Your Ref: OWPC25514
Our Ref: P/115/19/PDH 02-01-2020
Please ask for:
Finlay Gardner

Town and Country Planning Act 1990 (As amended)
Town and Country Planning (General Permitted development) Order 2015 Schedule 2 Part 1
Class A

Notification under extended permitted development rights for a rear single storey extension measuring 6m from beyond the rear wall of the original dwelling house, with maximum height of 3.62m and eaves height of 2.35m
90 Pagham Road Pagham

PROPOSED CROSS SECTION 'AA'

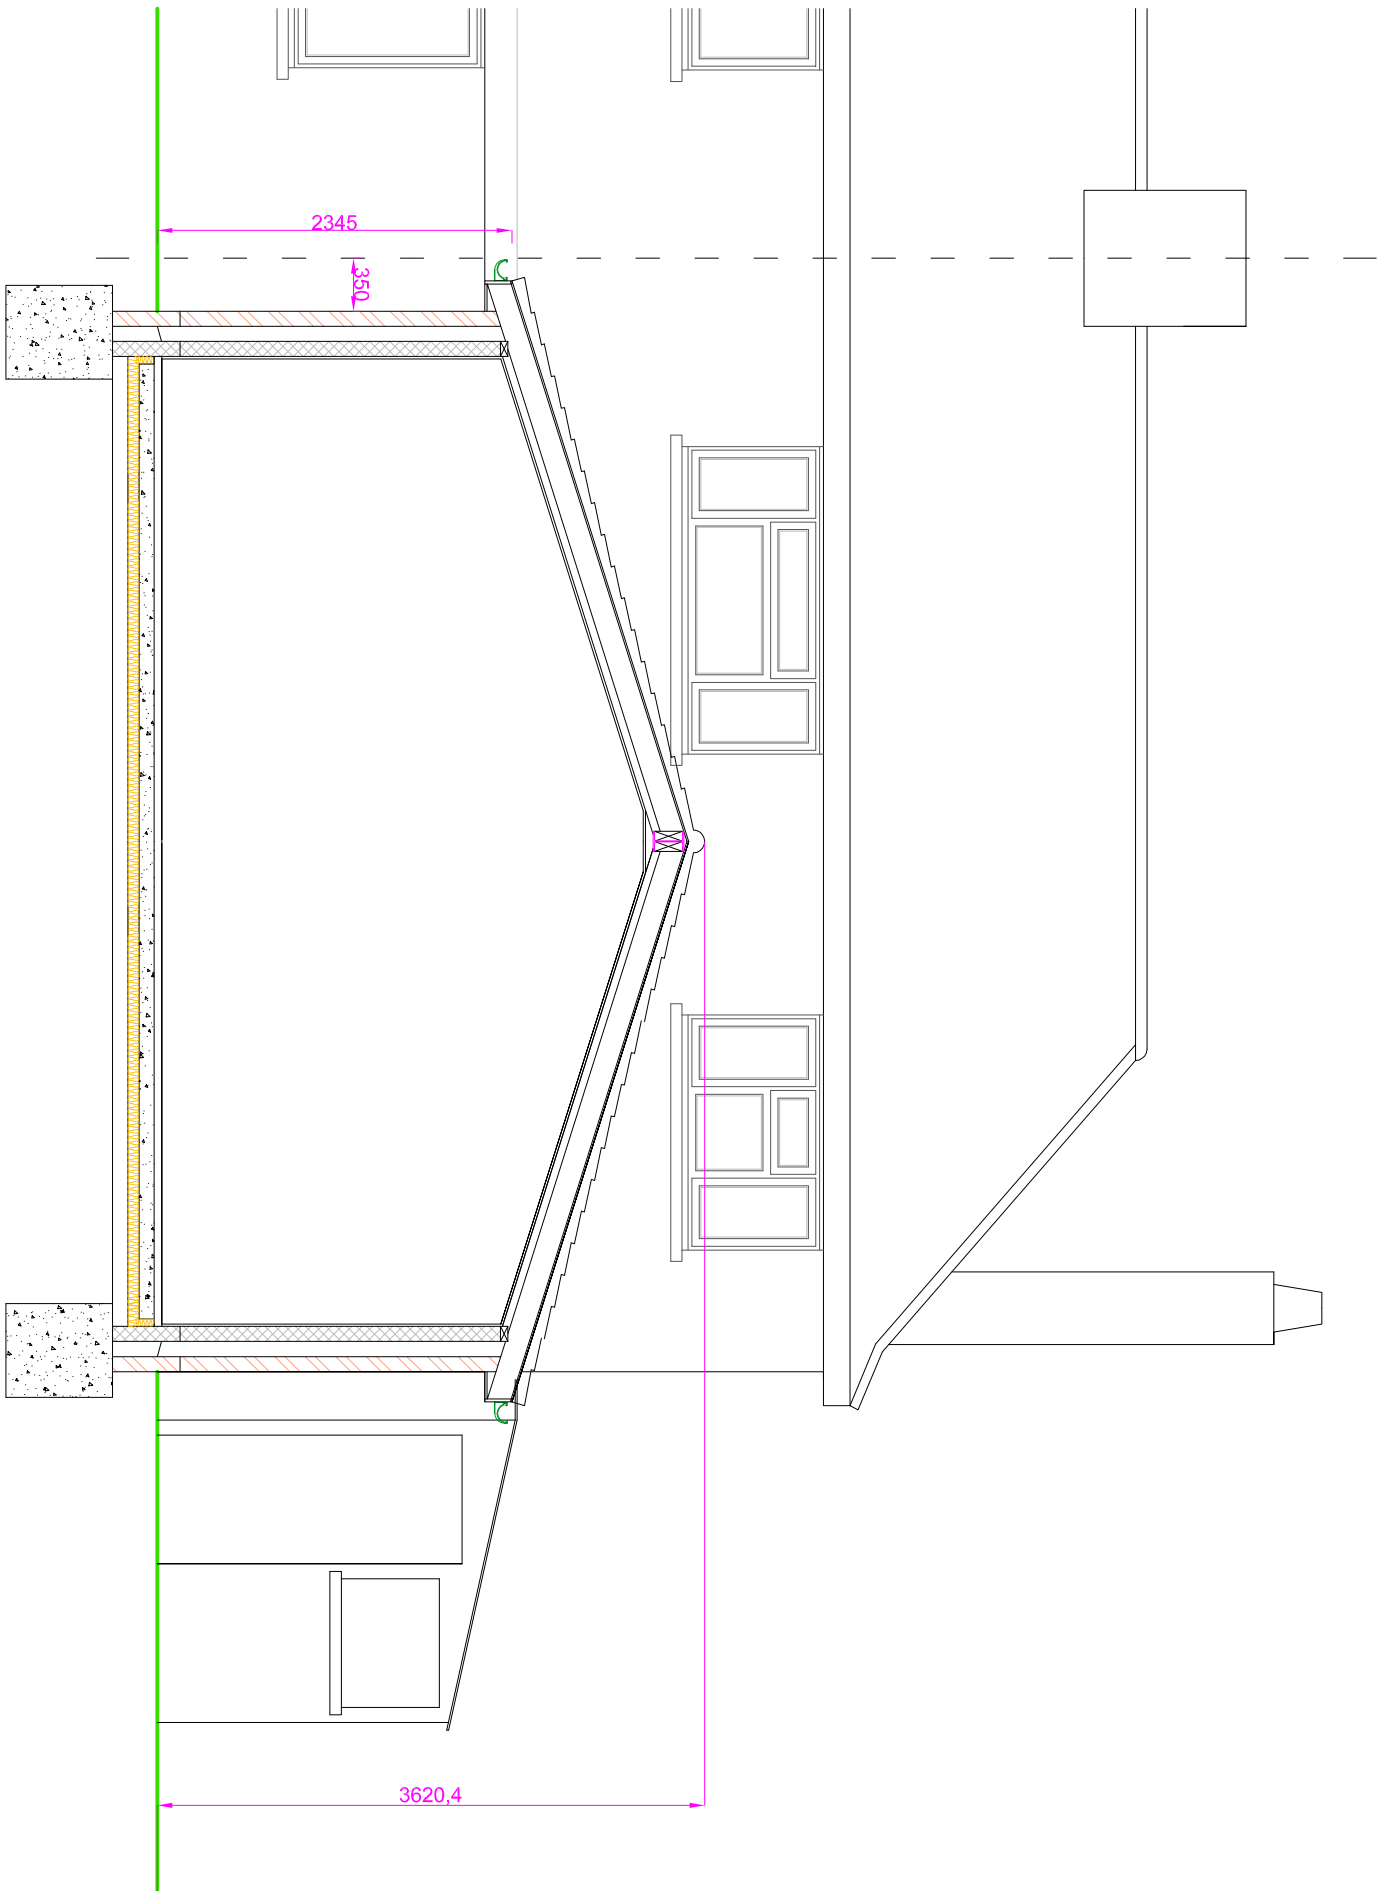
This will block out the light in my lounge and my garden due to the size and pitched roof design.

I would only see a brick wall and a roof from my lounge now instead of the skyline. Also I have studied the dimensions that have been shown and because this is so ridiculously large its going to put my patio area (where we spend most of our summers sat in) in the shade. Following on from that because of the height and the pitched roof it is also going to put my entire lounge in the shade and no sunlight will project in.
